REQUEST

Current Zoning: N1-D (neighborhood 1-D), N2-B (neighborhood 2-B), and B-1(CD) (neighborhood business, conditional).
 Proposed Zoning: N2-A(CD) (neighborhood 2-A, conditional)

The petition proposes the development of up to 29 multi-family attached dwelling units. The site is currently developed with a commercial building and a material storage yard.

PLANNING STAFF REVIEW

# RZ.01

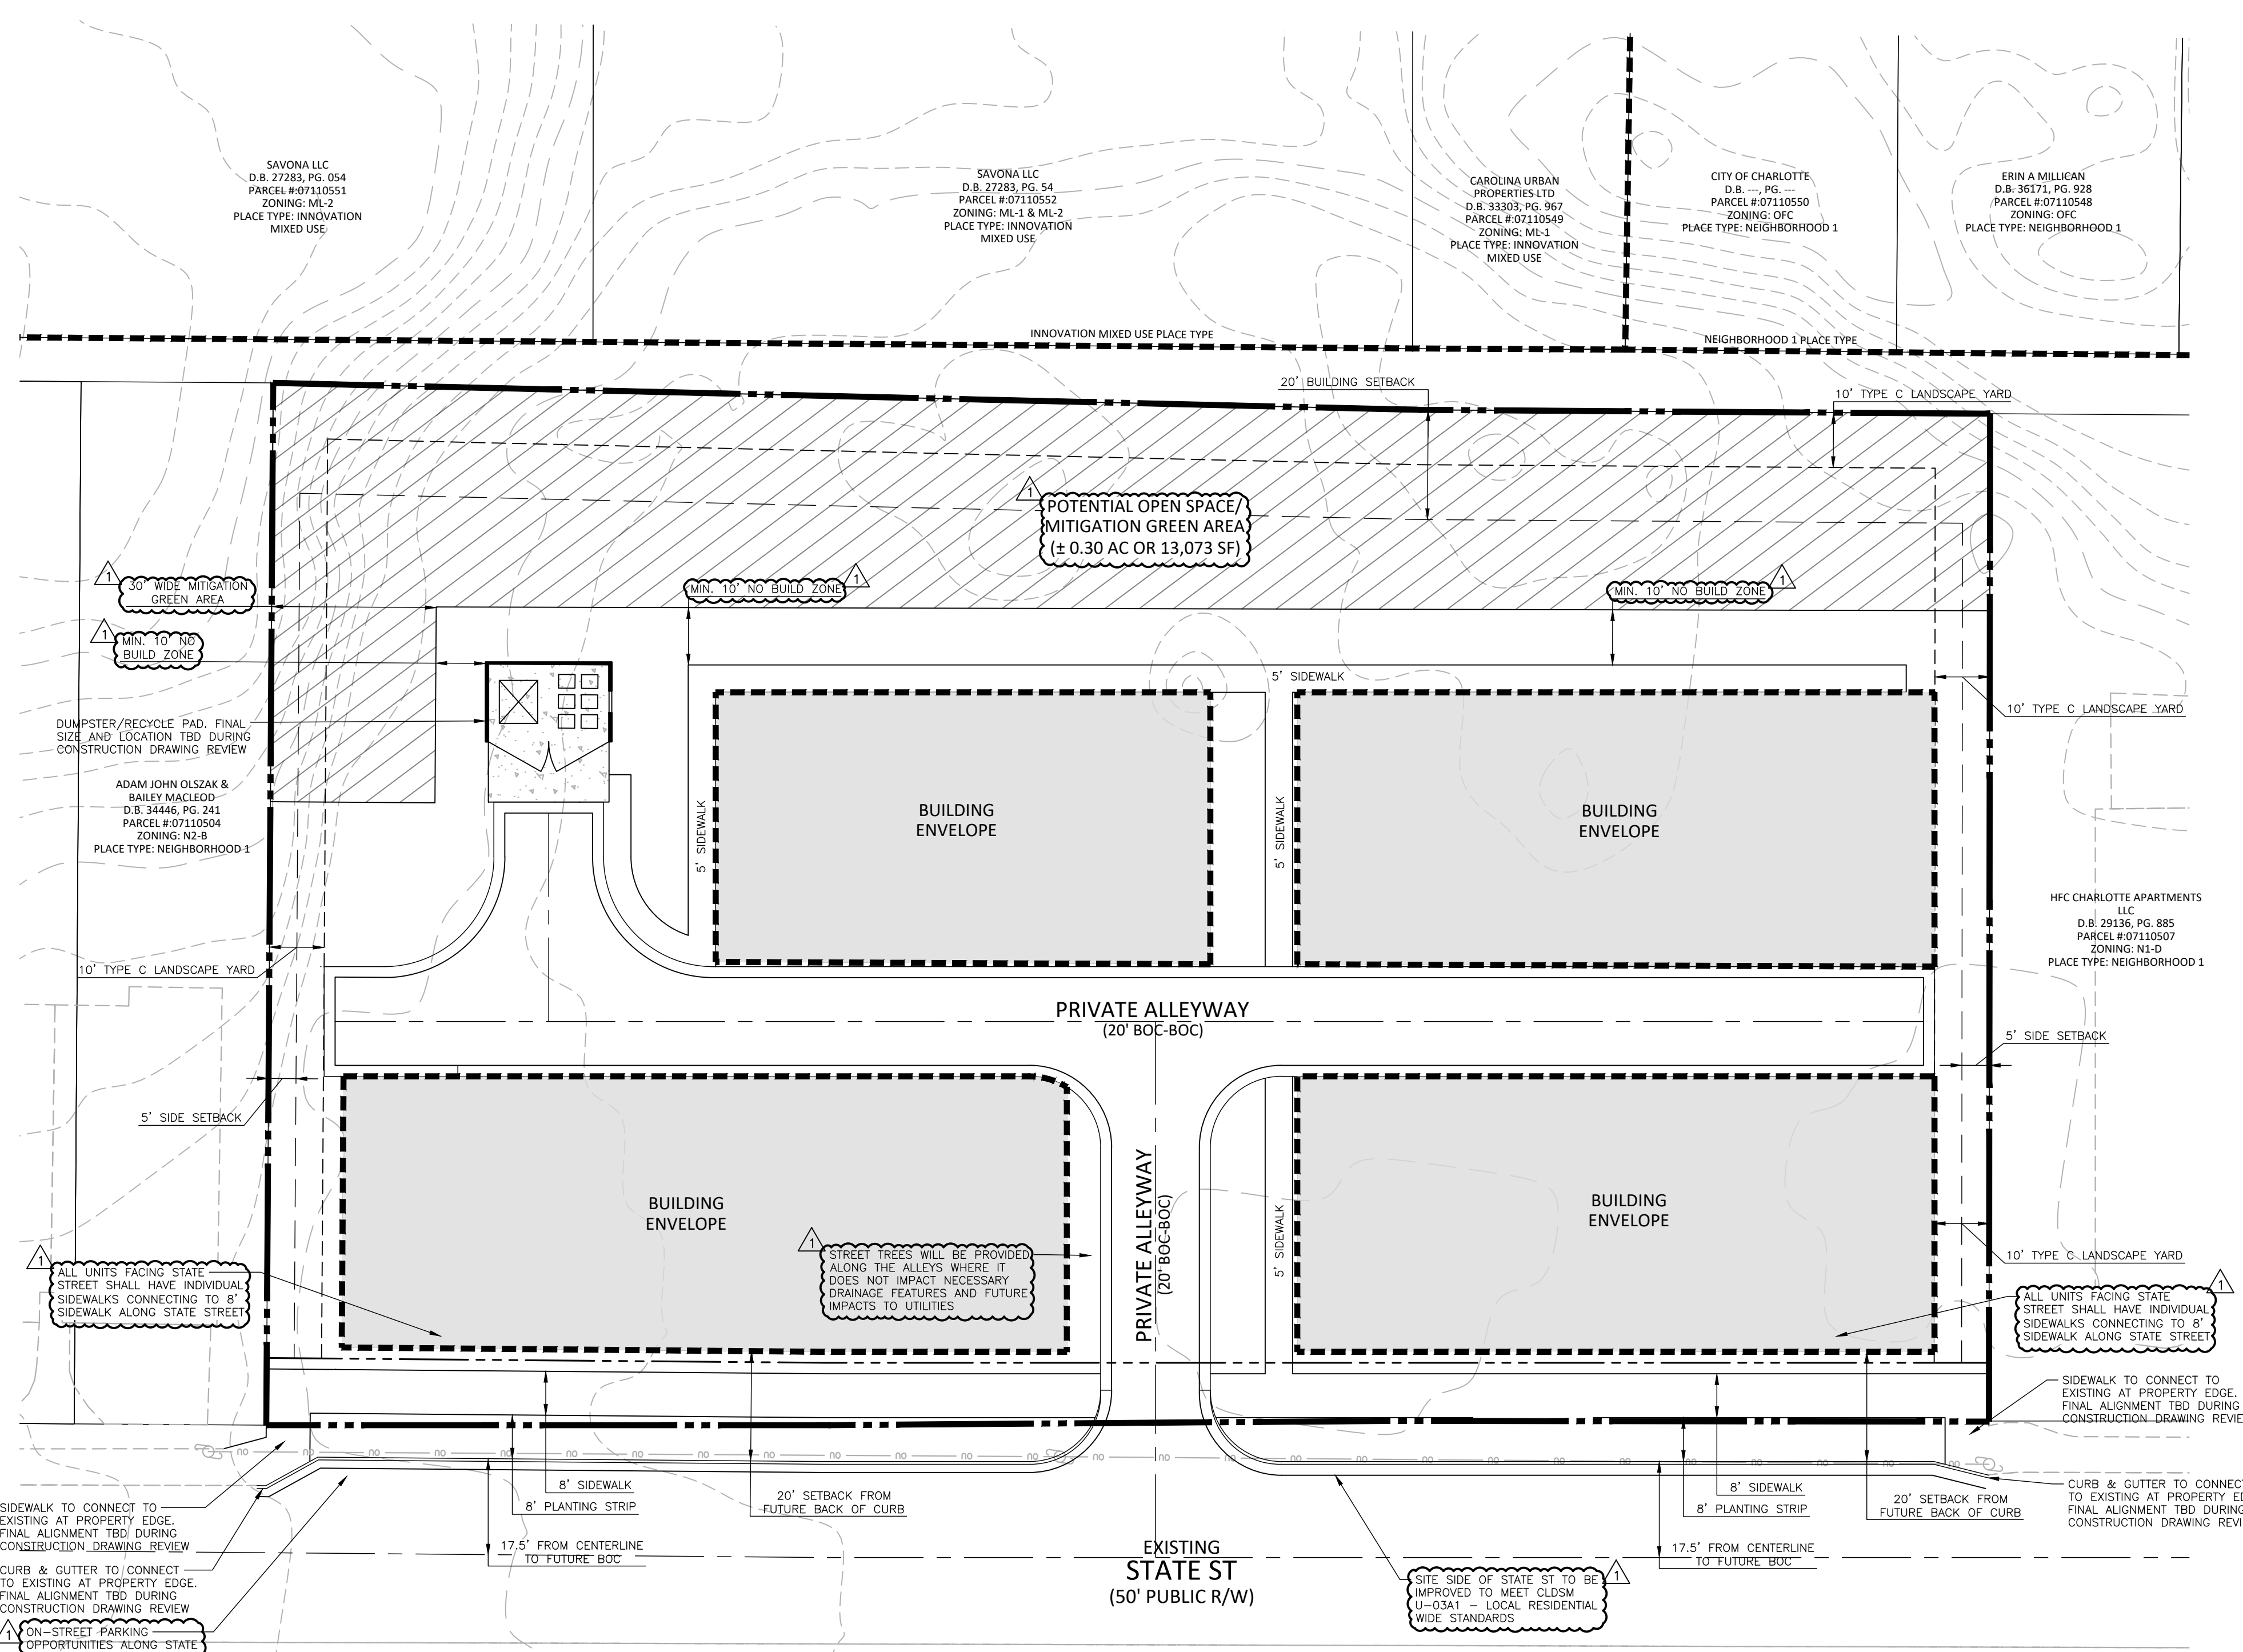
1. Entitlement Services: specify a minimum number and maximum spacing for proposed alley street trees.
